# ENG-PUDSP20003-R2-PDR-redlines.pdf Markup Summary

**Subject:** EPC ENG Review  
**Page Index:** 1  
**Date:** 10/15/2020 3:31:38 PM  
**Author:** dsdrice  
**Color:** ■  
**Layer:**  
**Space:**  
**Page Label:** 1

**THE HILLS AT LORSON RANCH  
 OVERLOT EARLY GRADING AND  
 EROSION CONTROL PLAN**

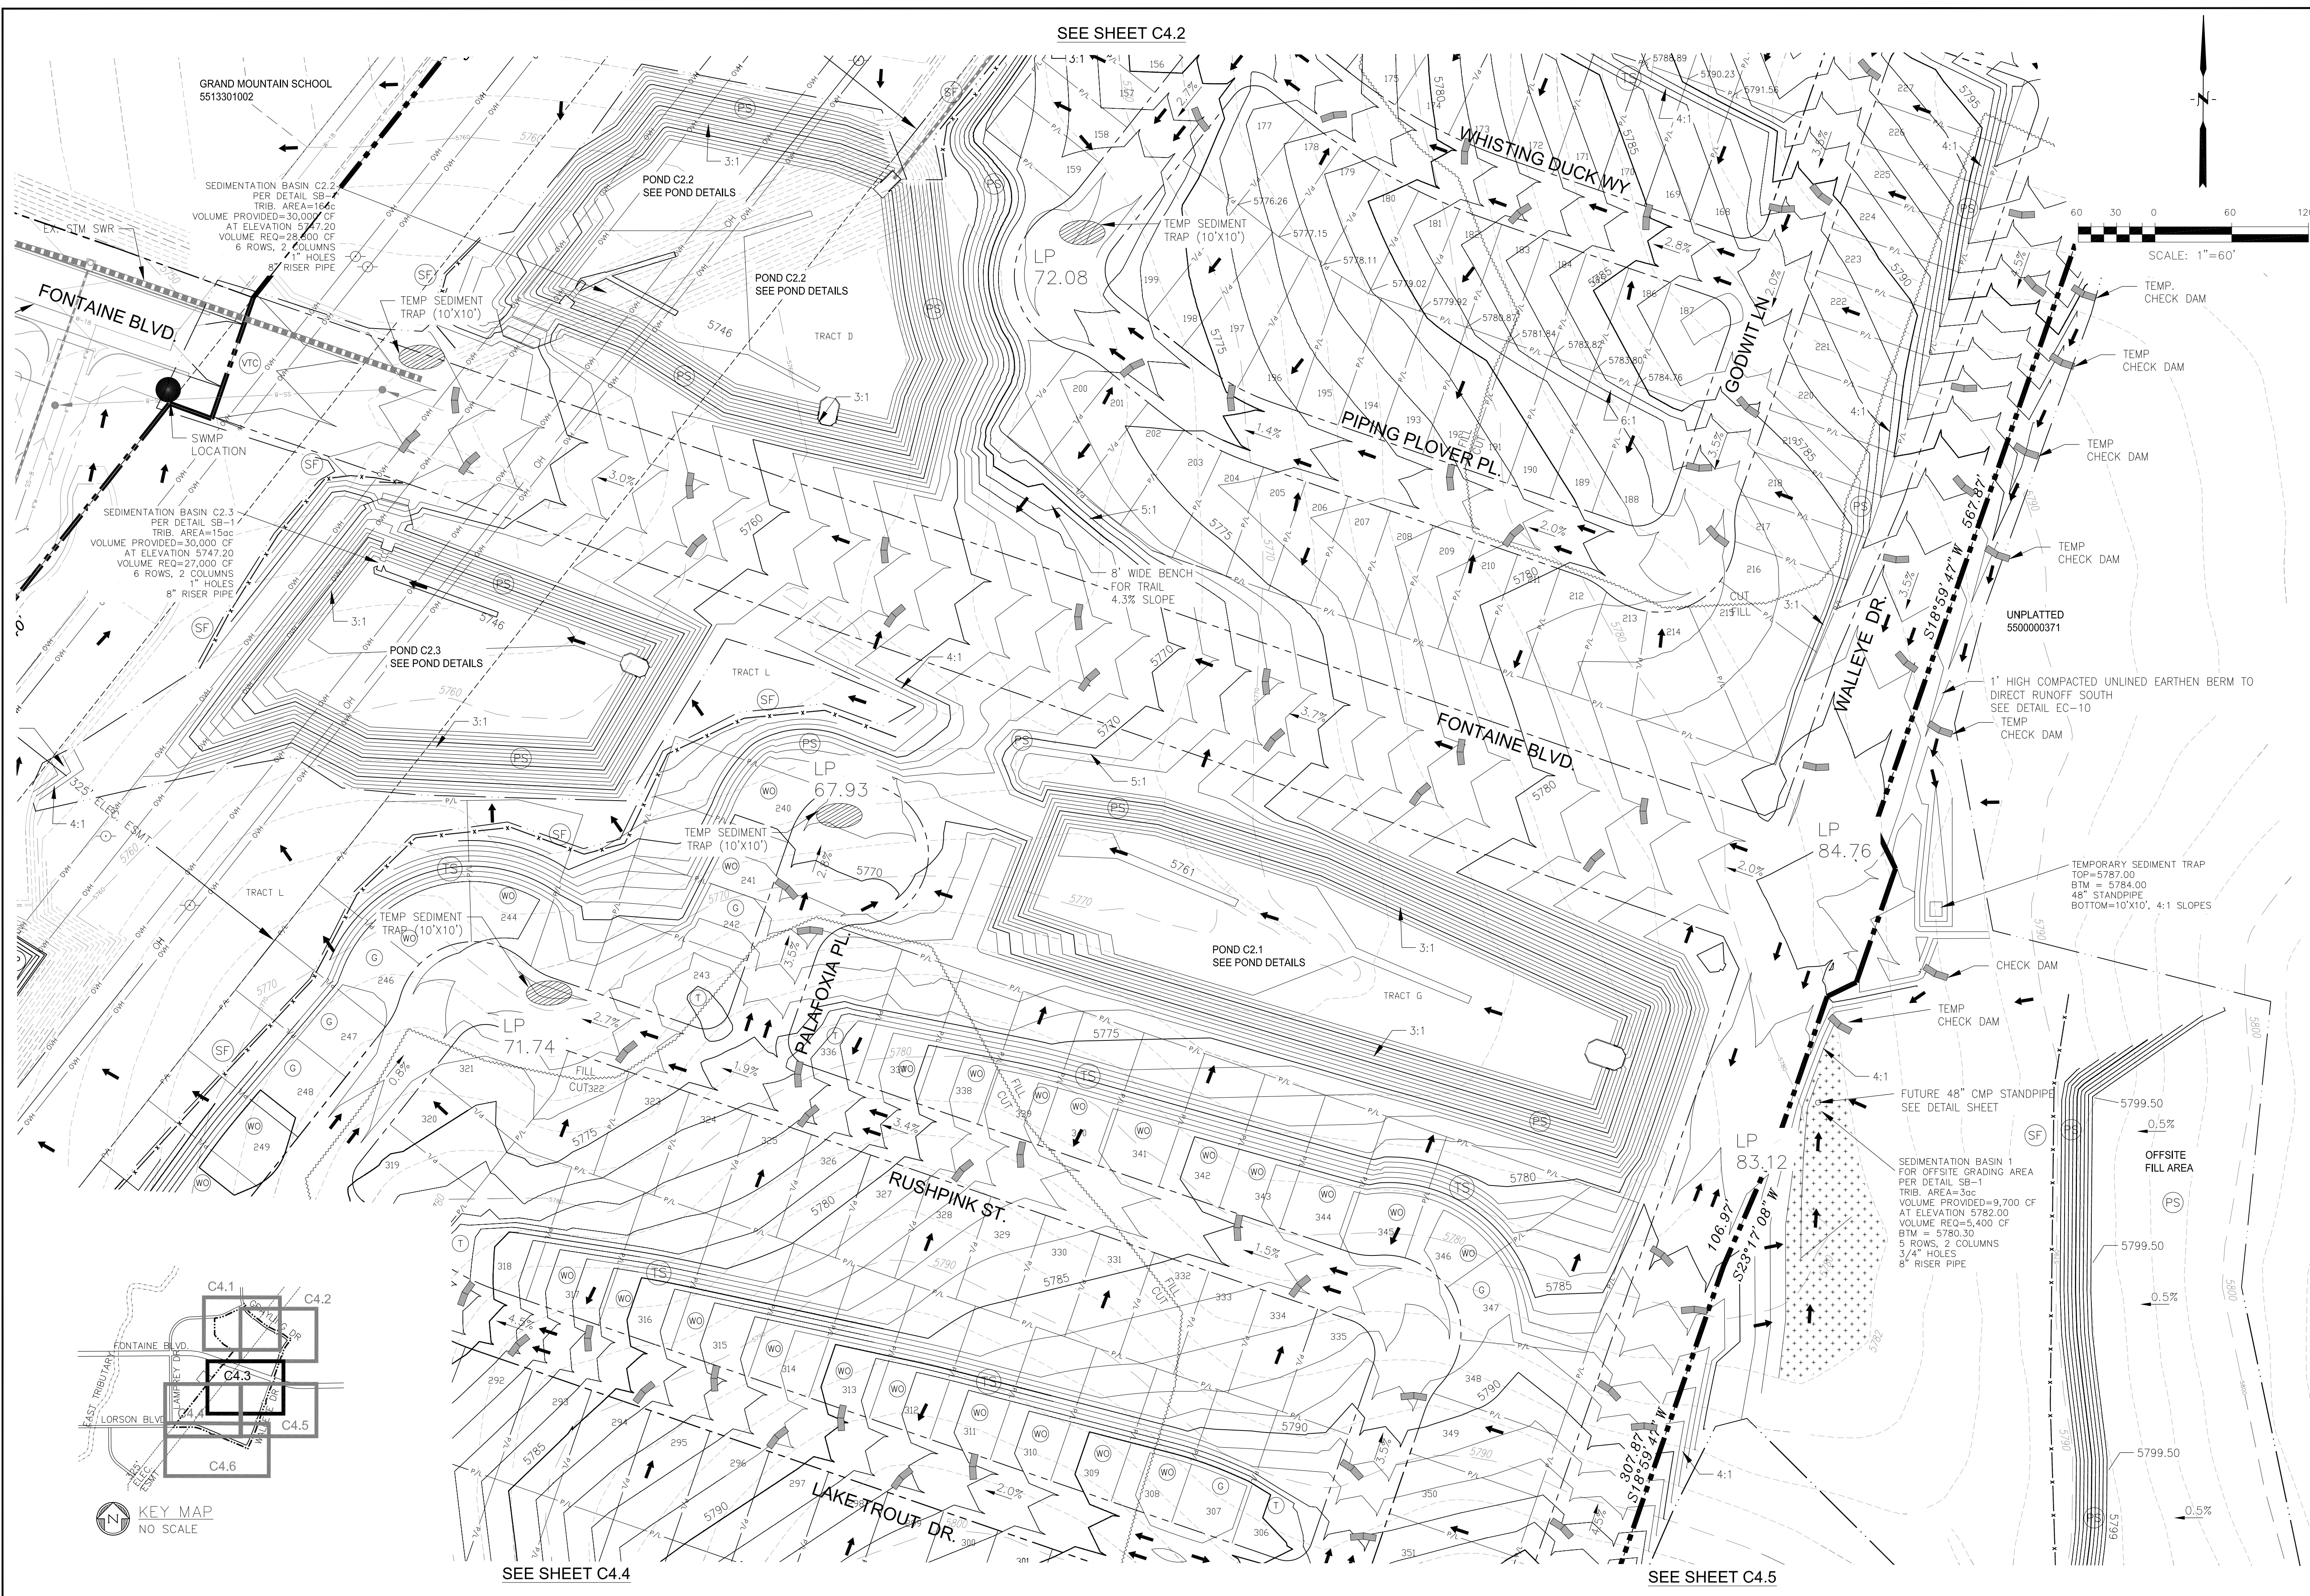
Show and label interim diversion berm/swale

Show and label interim diversion berm/swale

**EXISTING POND C1 EXPANSION**  
**POND GRADING AND**  
**TRICKLE CHANNEL**

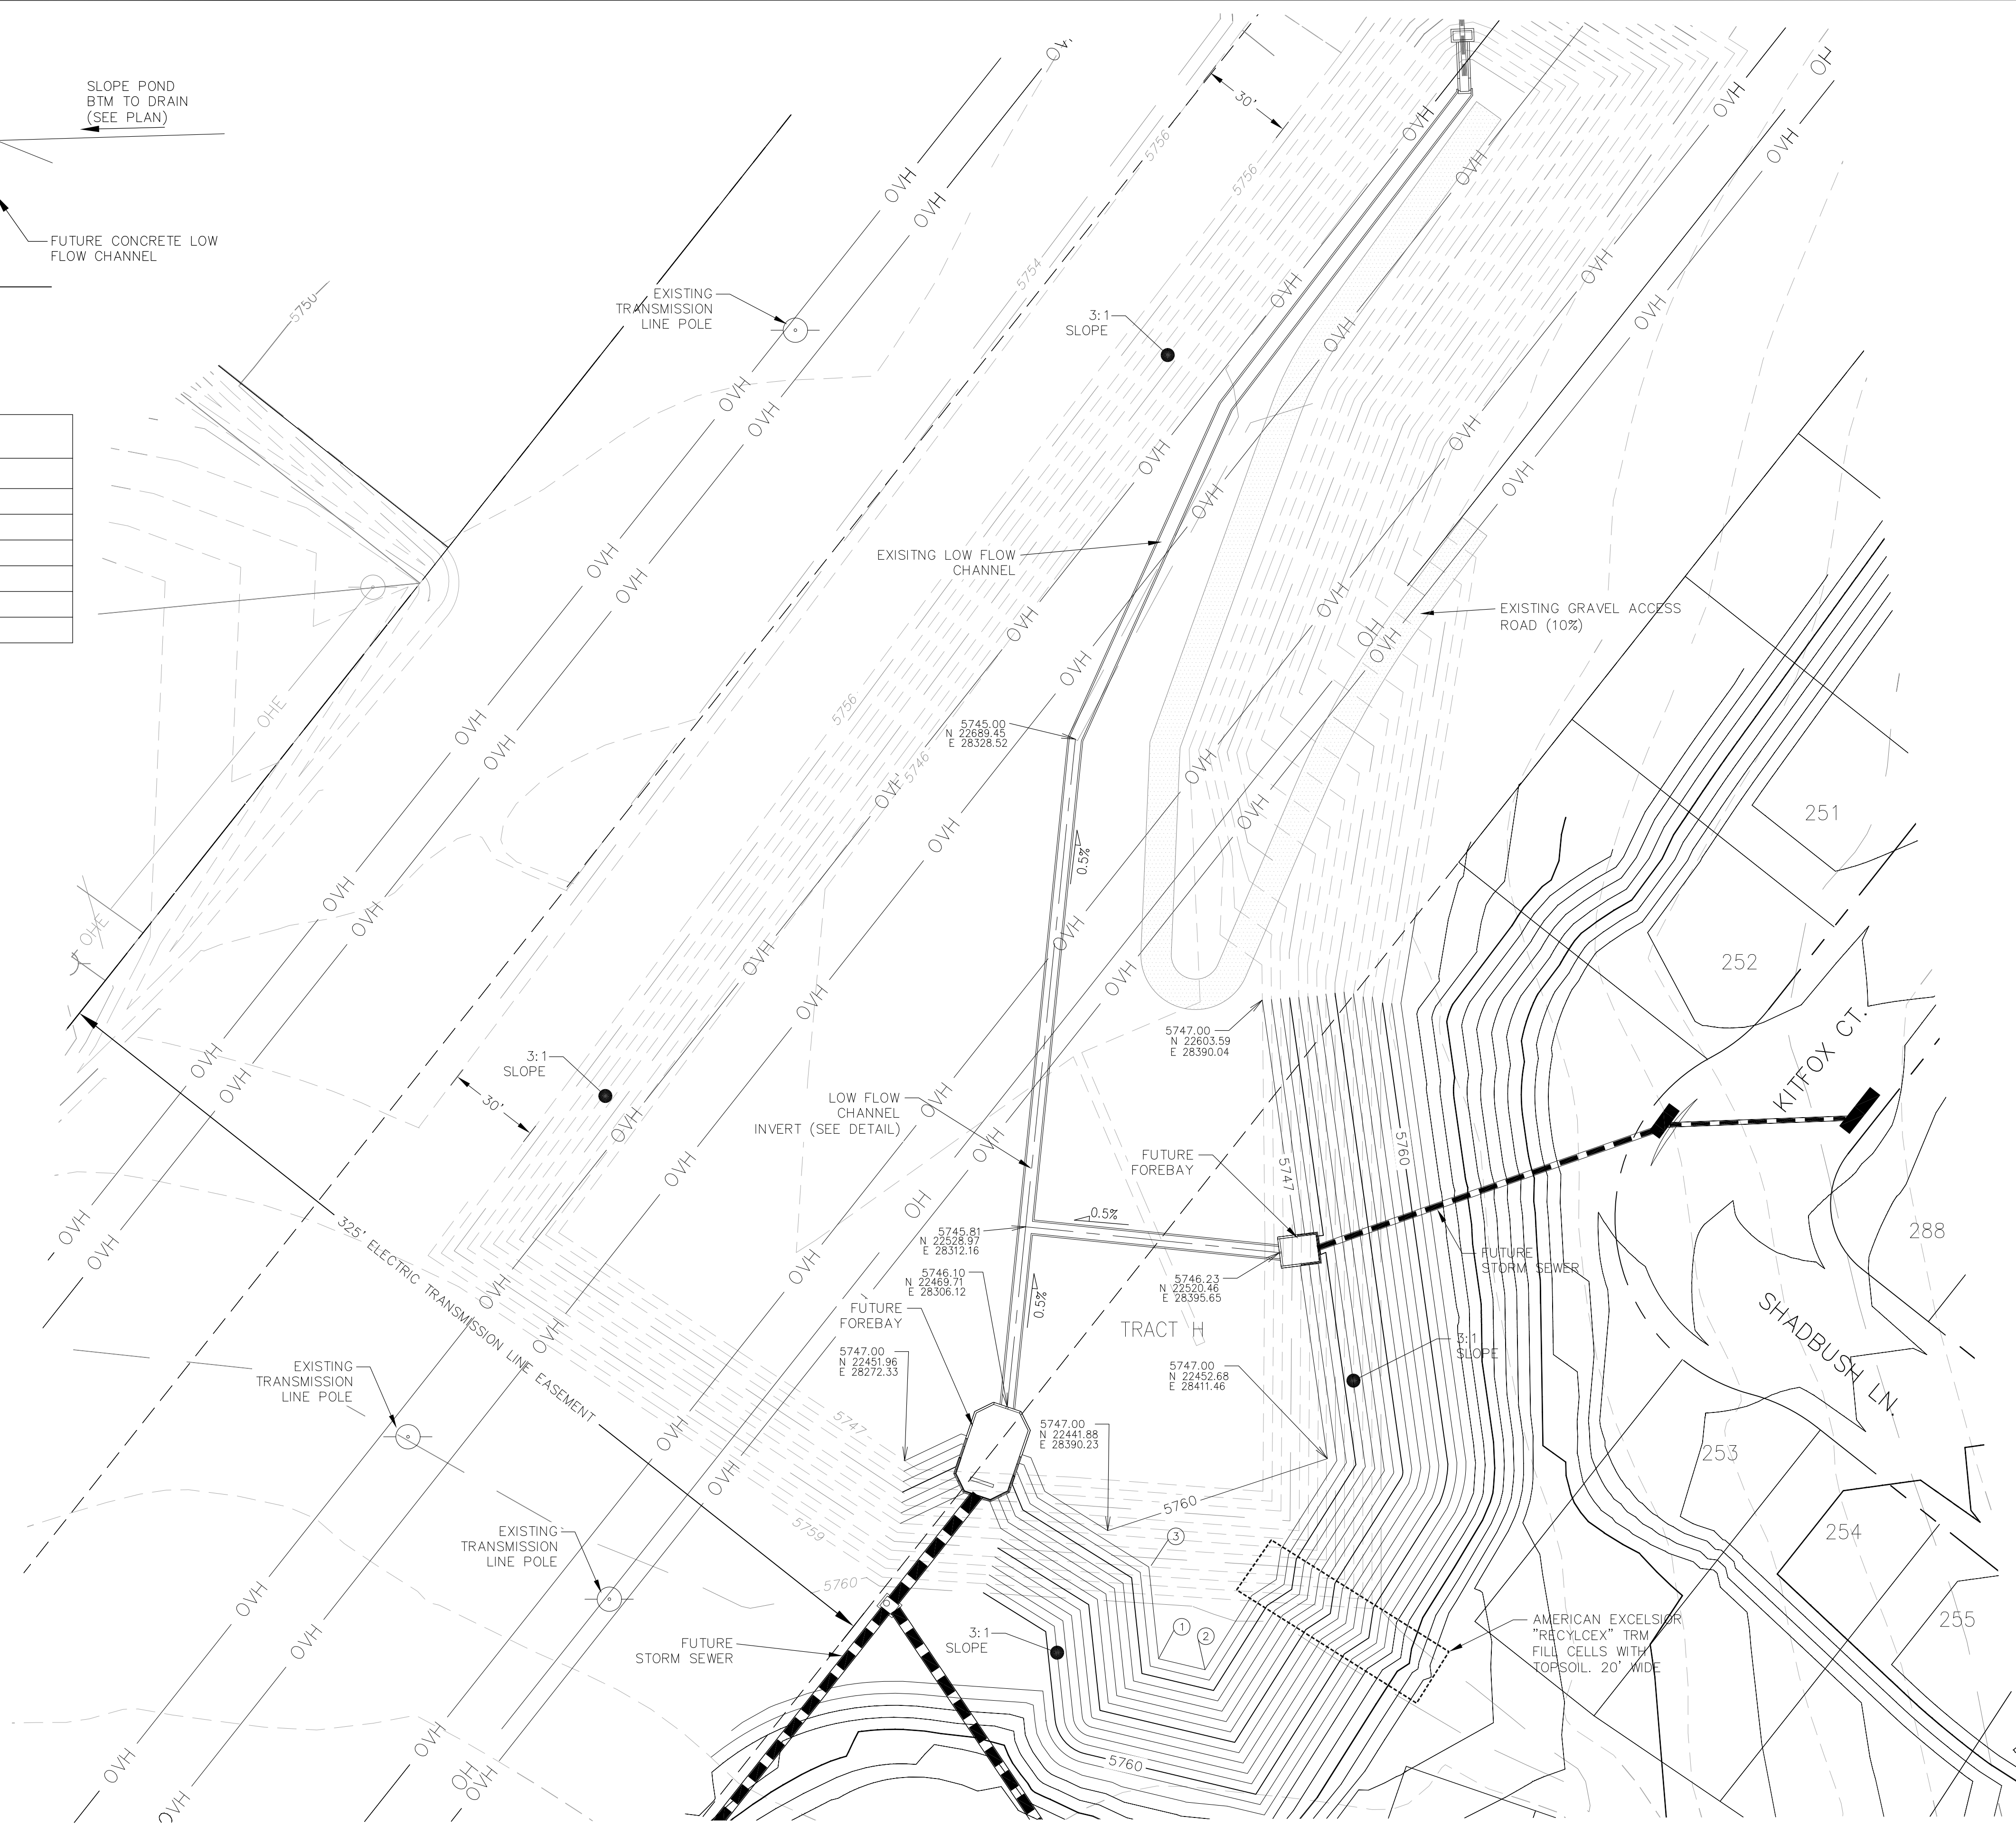
C1?
